PUBLIC TESTIMONY
MERCER ISLAND PLANNING COMMISSION
01/30/19

City of Mercer Island Planning Commission, Staff, and Council:

1. The "tiered" system: Small Sites vs Large Sites.

PRELIMINARY STUDY
HERZL - BUILDING HEIGHT
1"=50'

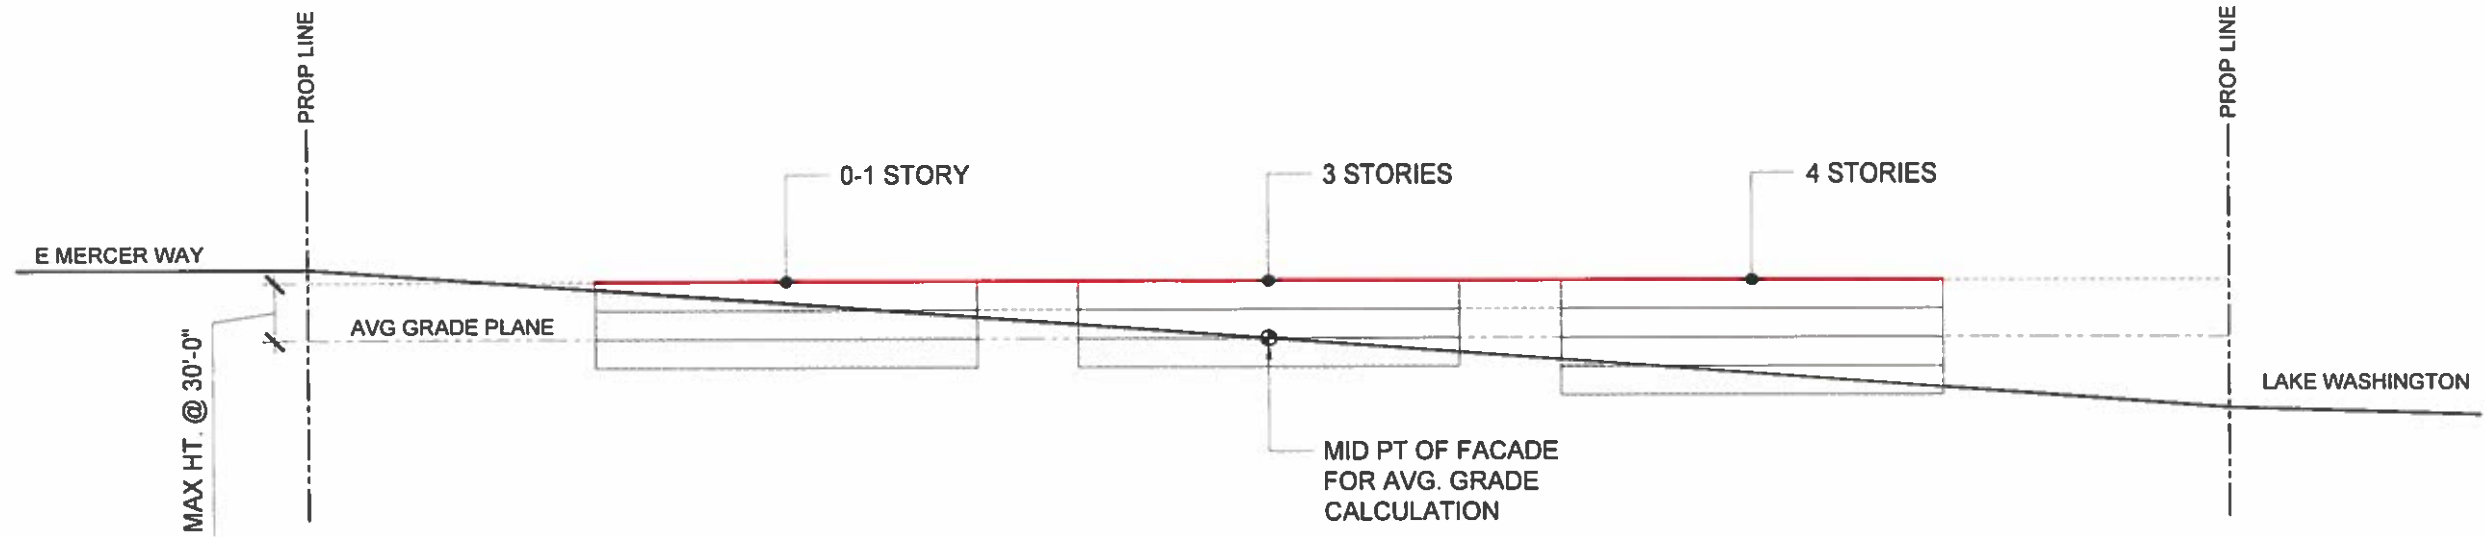
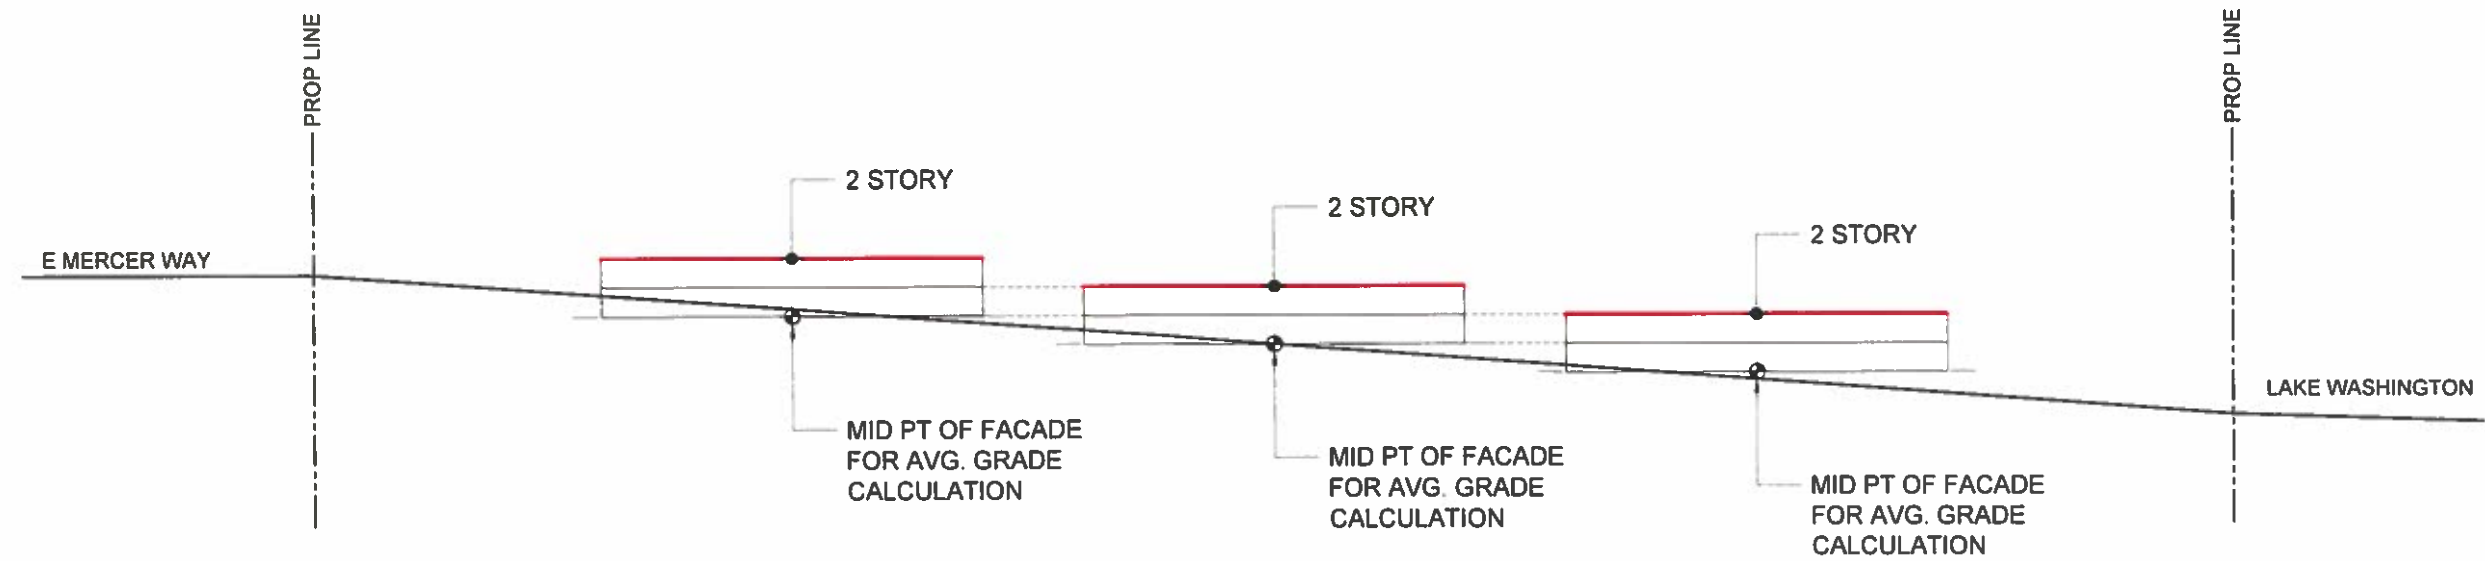
The next page in your packet shows two methods of height measurement. The code prescribes the former – setting a single height for the entire structure – a practice ill-suited for development on sloping sites. We suggest the latter, which will allow buildings to step with the grade, reducing overall bulk and scale and better accommodating critical functional aspects such as getting adequate light and air to students.
